# **ADDENDUM #1**

**Iris Park Apartments L.P.**

**Portland, Maine**

RE: Addendum No. 1 to the Bidding Documents for:

SKS-05

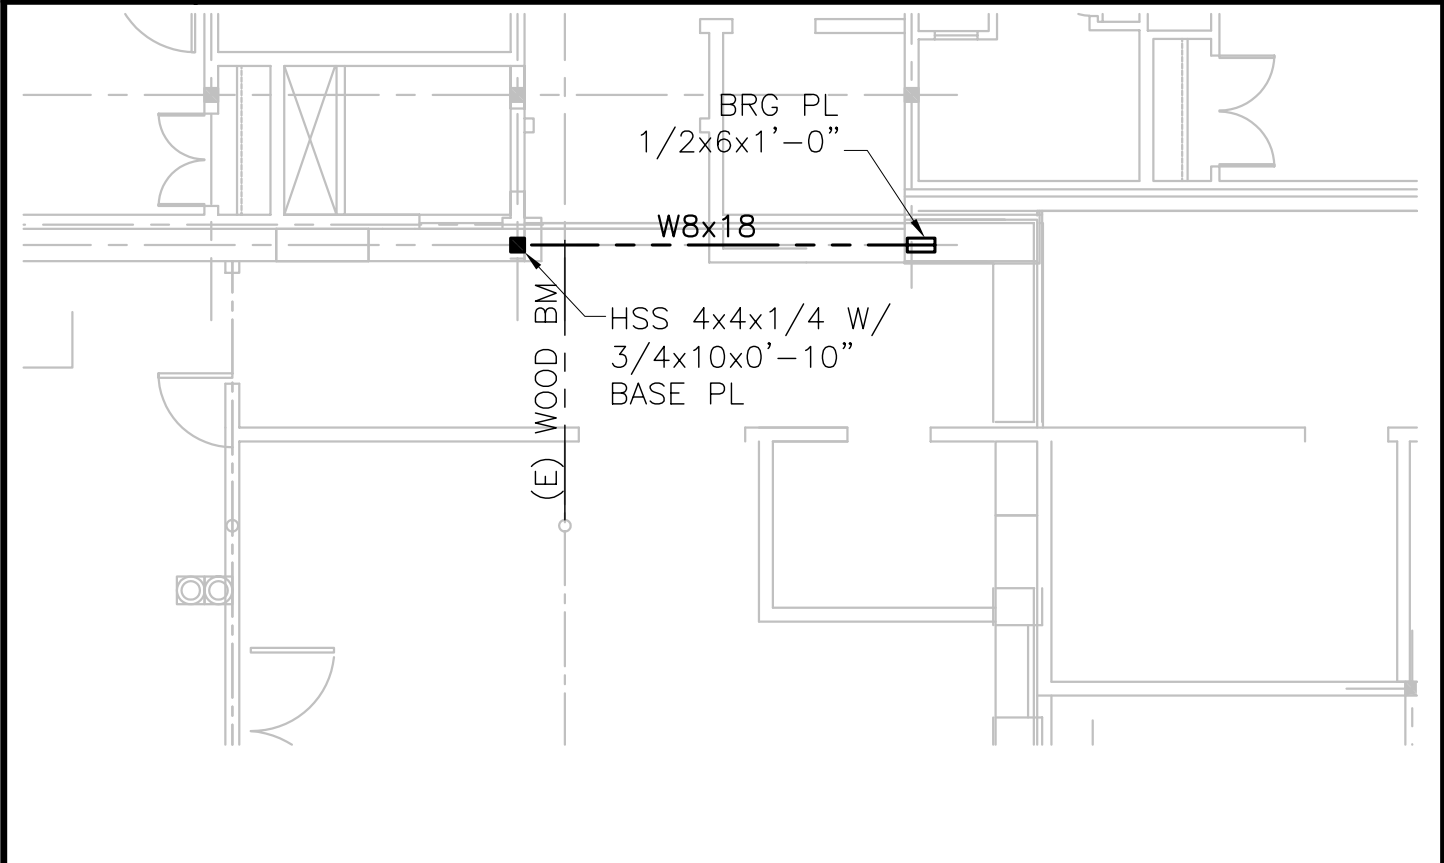
**SKS-05** – Partial Framing Plans

**ASK**  
**5**

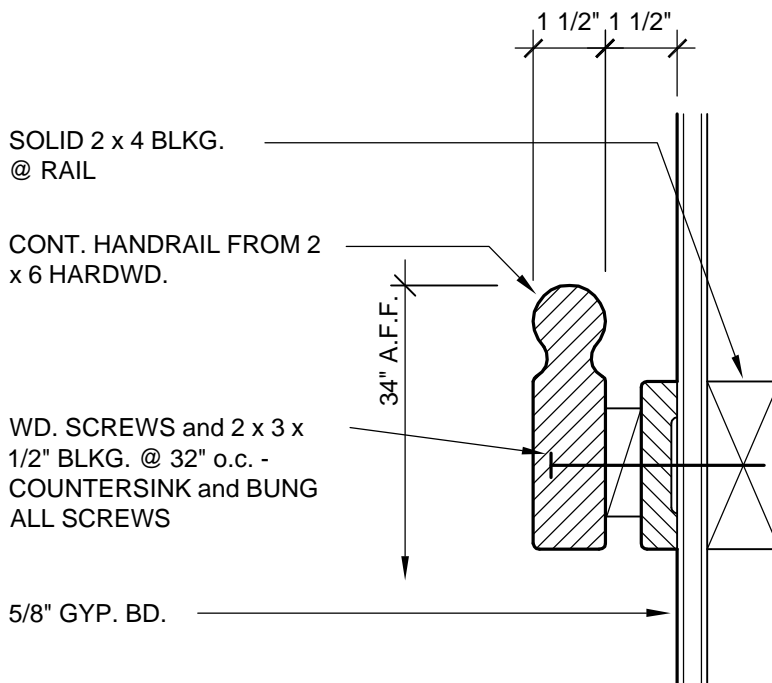
**ASK-5 – Chair Rail and Hand Rail Details**

1  
SKL-1

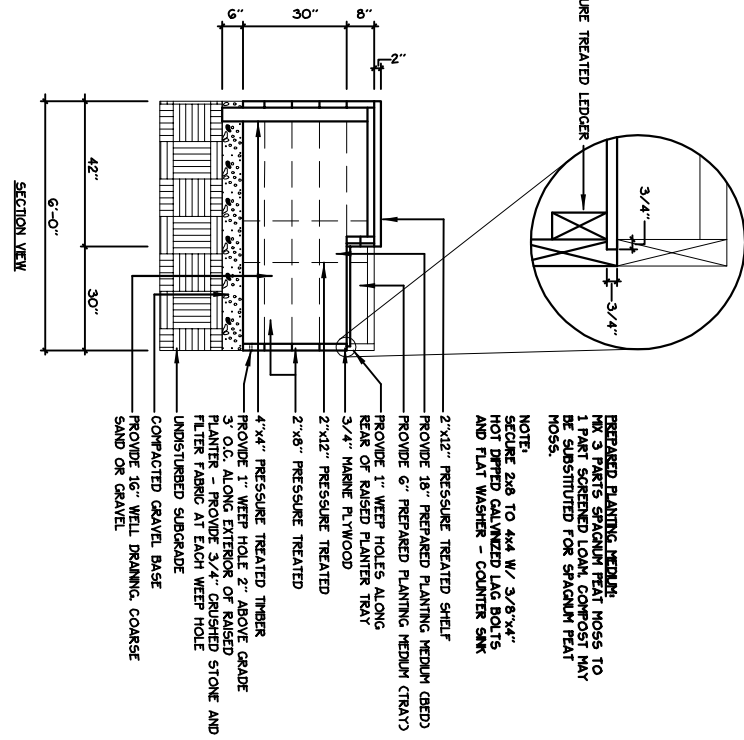
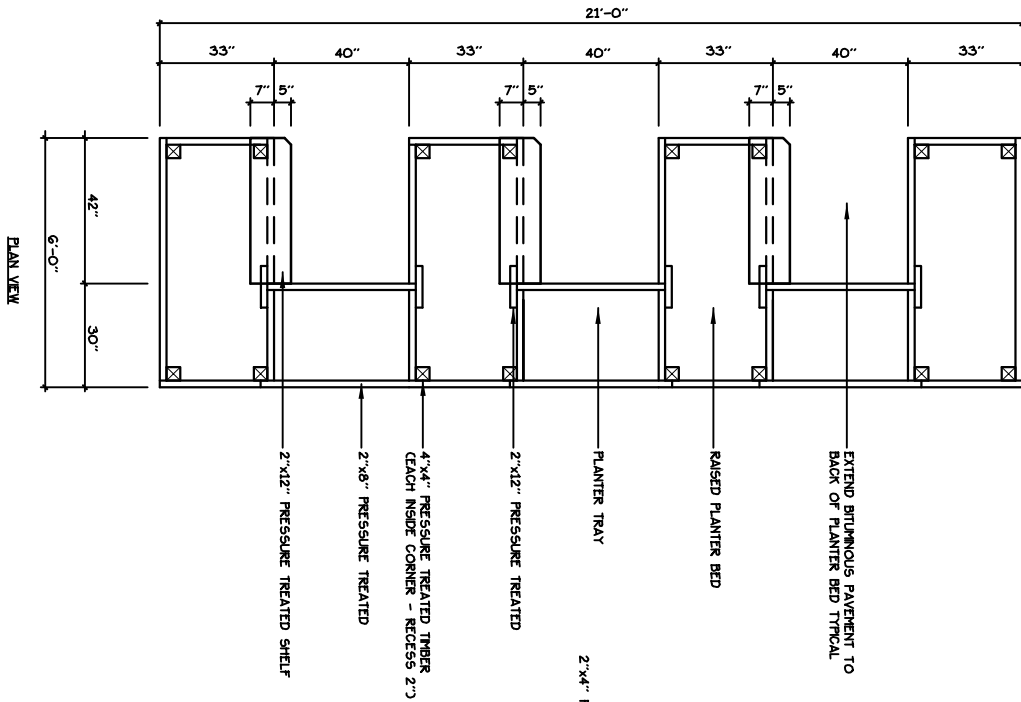
**SKL-1-** Raised Wheelchair Accessible Planter
